ENG-SF20028-R4-Plat.pdf Markup Summary

Subject: Text Box
Page Index: 1
Date: 8/25/2021 10:59:35 AM
Author: dsdrice
Color: 
Layer:
Space:
Page Label: [1] Constitution & Hannah PLAT-S1

DATE OF PREPARATION:	03-19-2020
SCALE:	N/A
SHEET 2 OF 8

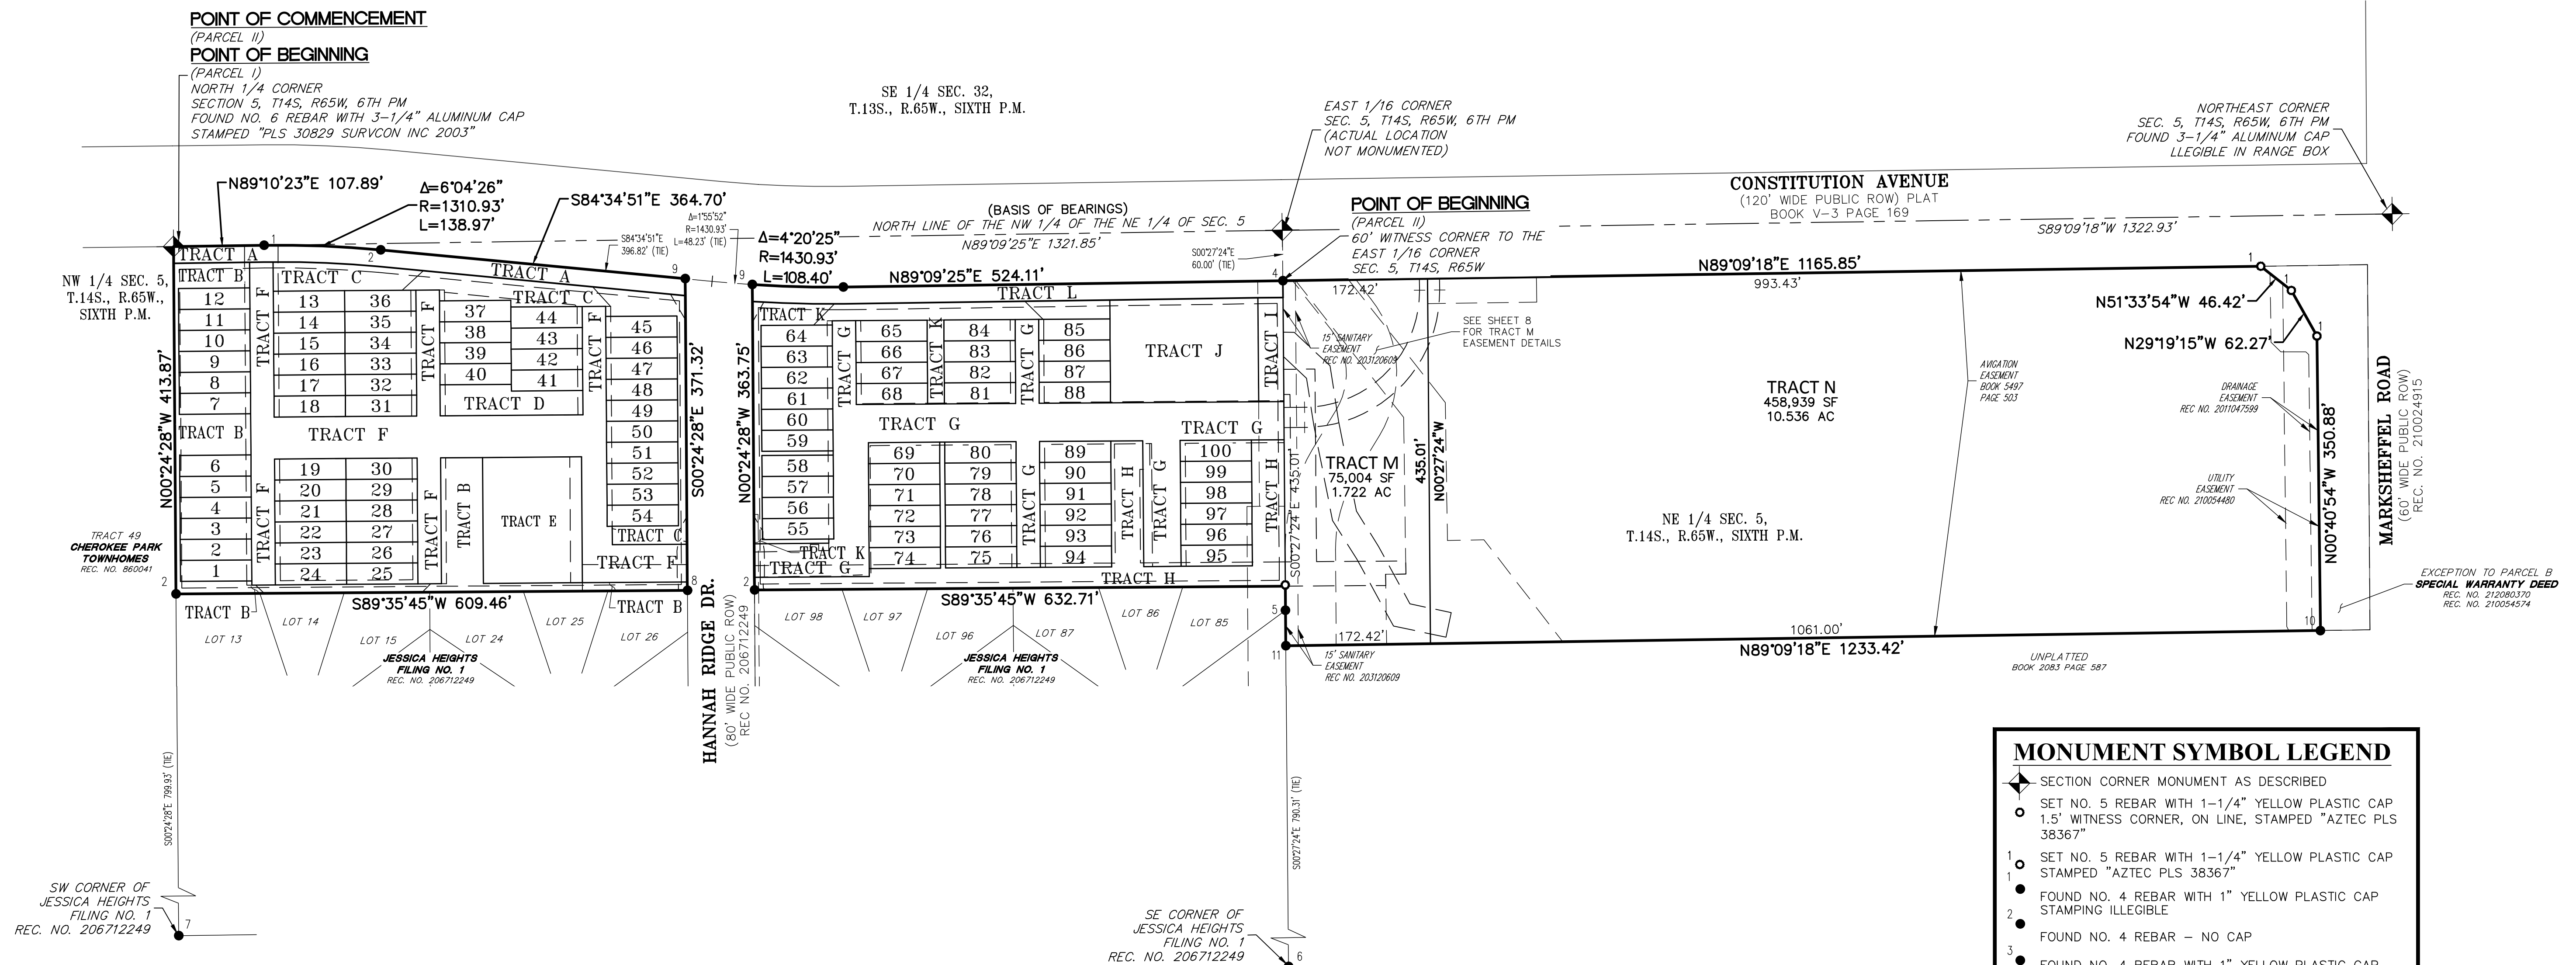
delete the number
- this is part of
note #22

delete the number - this is part of note #22

replace with "Parks and"

delete highlighted portion and replace with a sentence stating the HOA is the maintenance entity.
